**Canal &
River Trust**

Your Ref 2025/91184

Proposal: Erection of two storey industrial unit (Use Class E(g)(iii)), with associated car park, service area and other associated works.

Location: Land off Bretton Street, Savile Town, Dewsbury

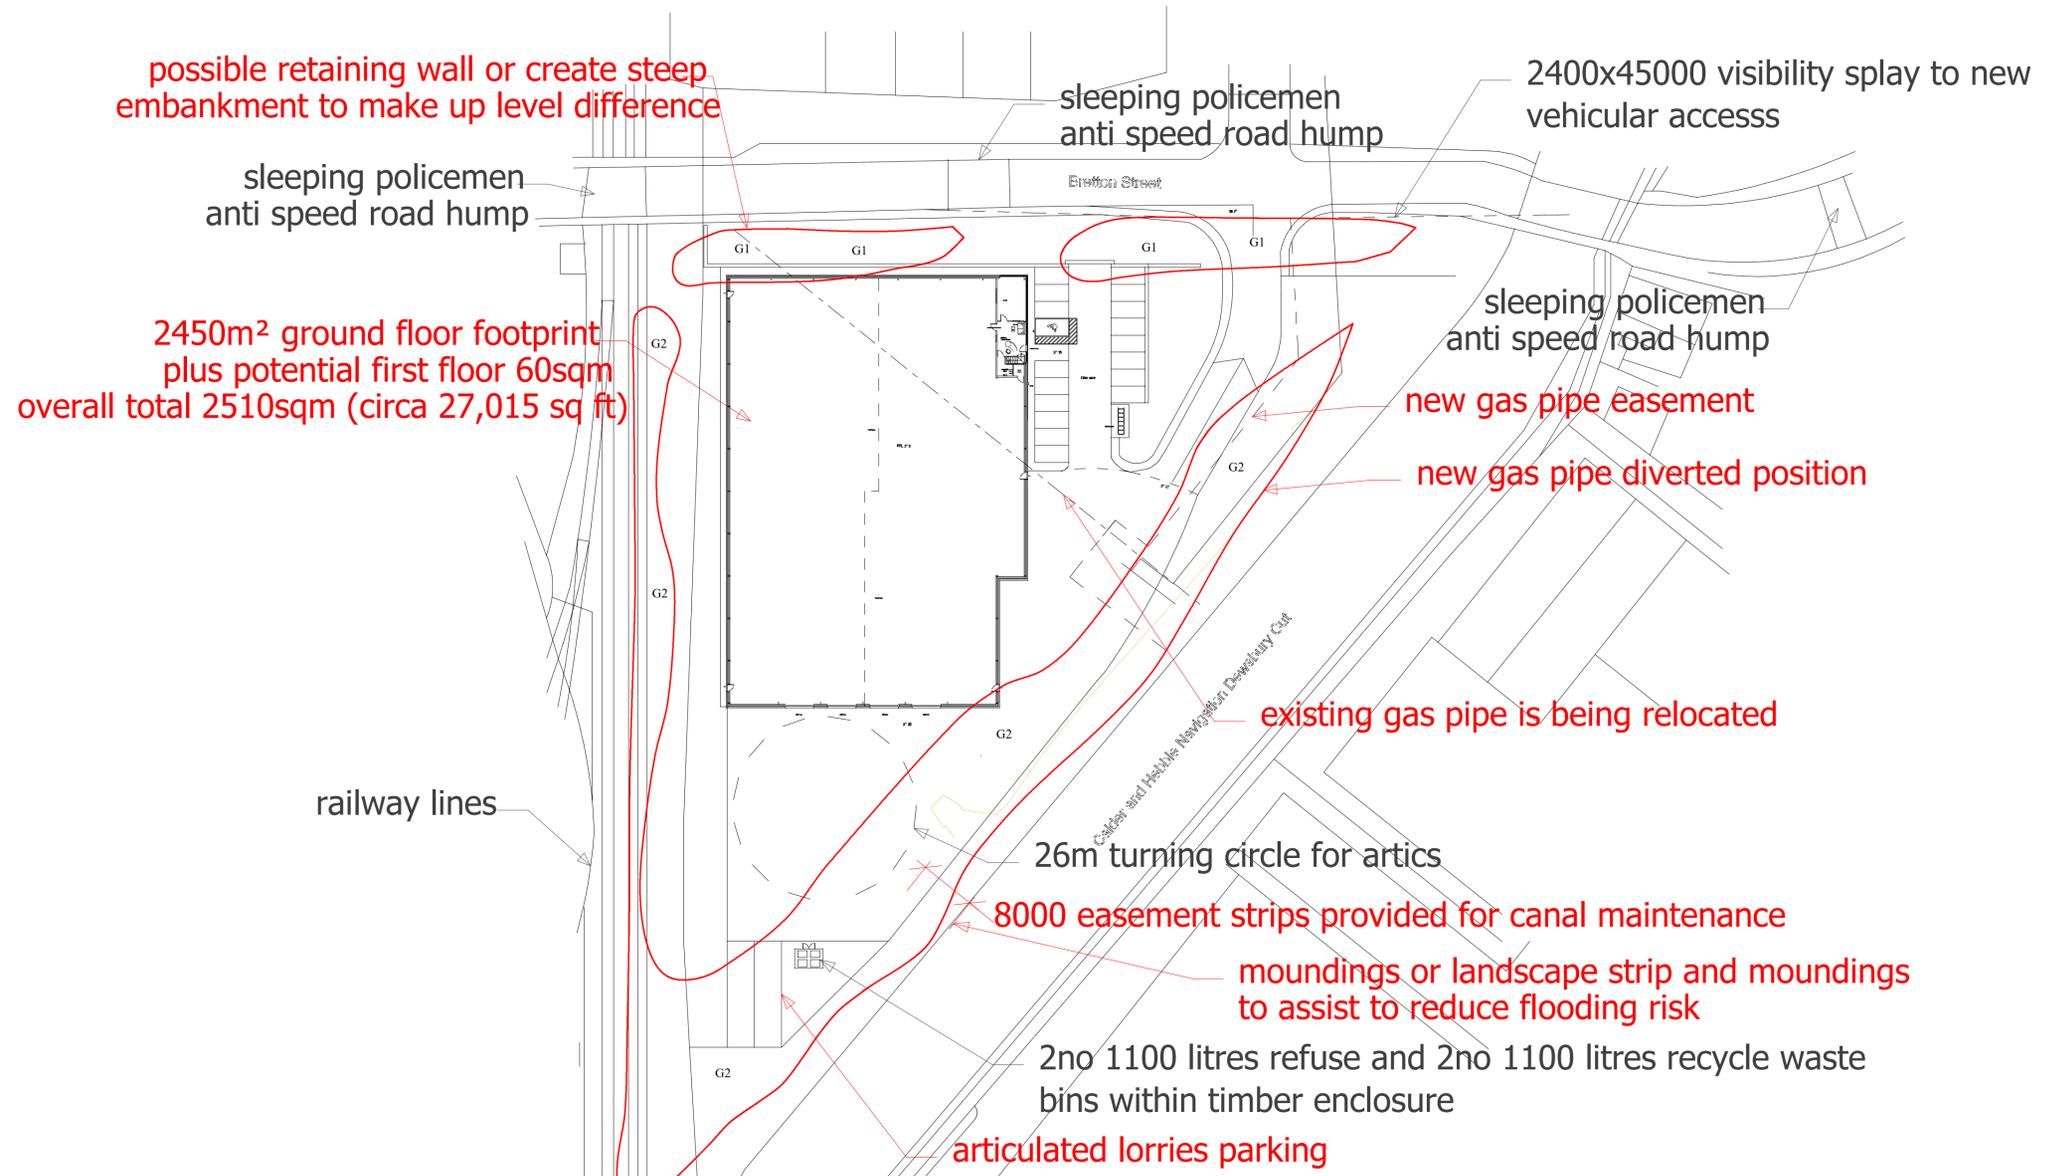
Paragraph 3.2.1 of the Arboricultural Impact Assessment identifies that the proposals will remove all trees on one side of the existing canal (group G2), which would likely alter the character of the canal-side area, and would remove existing species that contribute towards the tranquil and semi-natural character of the existing waterway in this location.

NATIVE HEDGE

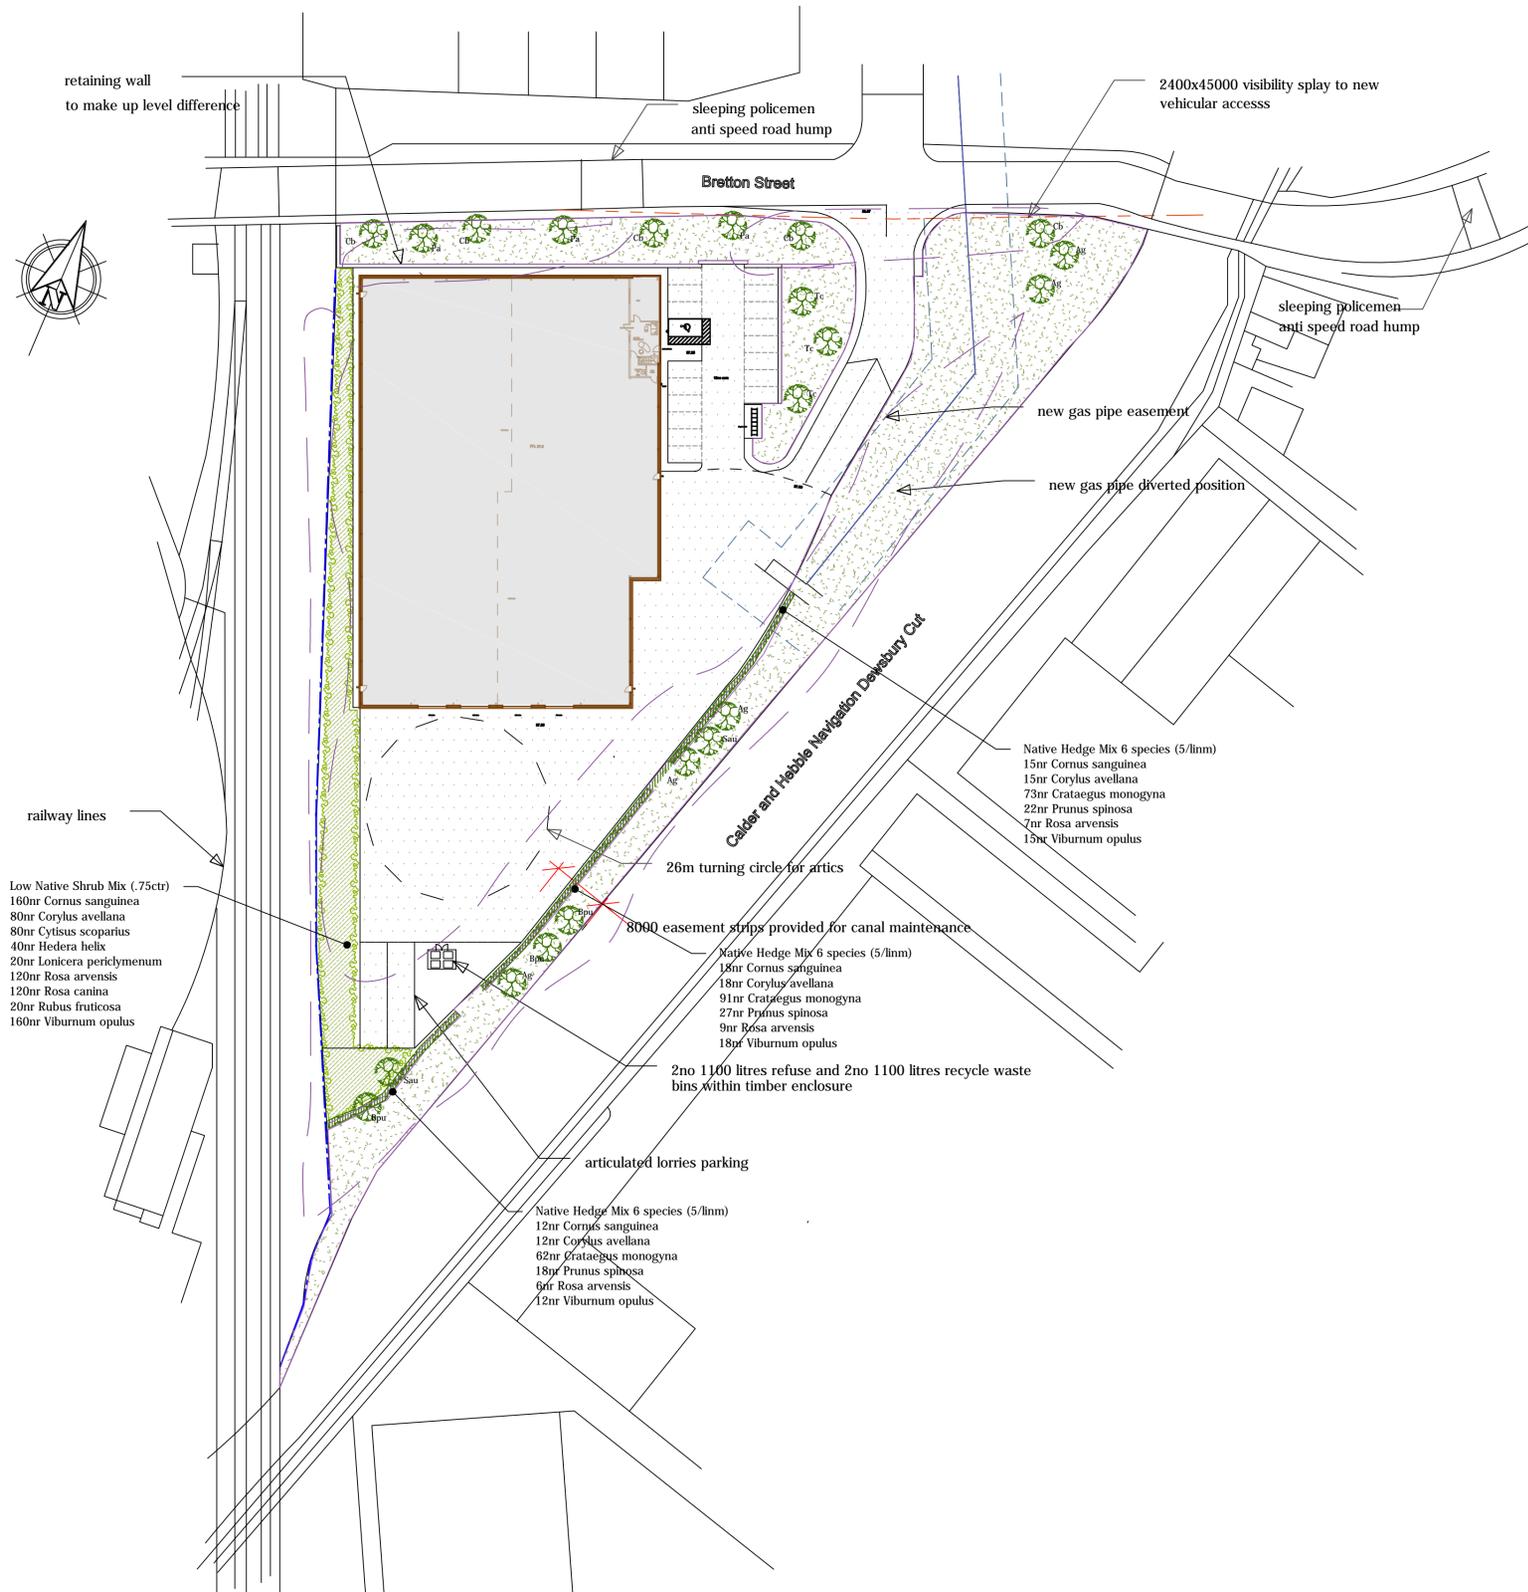
We appreciate that the development is shown to be set back from the canal. However, the proposed landscaping proposals comprise of low-growing planting which is unlikely to sufficiently mitigate the visual impact of the 9m-high industrial building, and would be unlikely to screen the goods yard and associated HGV activity. The supplied aerial view is misleading, as it mainly shows replacement trees, contradicting the landscape plans that show a predominance of lower grass planting.

We request that a more robust tree replanting scheme is provided to soften the building's height and mass and to provide better screening to the business activities proposed. We wish to highlight that the Trust does not require an 8m easement to the canal (which is shown on the plant), which could offer better opportunity for improved planting on site.

We request that the landscaping proposals should be amended to increase the number of heavy standard native trees, particularly within areas of existing semi-mature broadleaved woodland, and measures should also be undertaken to enhance the understorey and shrub layer.

Should the proposed gas pipeline result in complications for the landscaping scheme, then we recommend that this is relocated further into the site to preserve the canal-side buffer for meaningful tree planting.
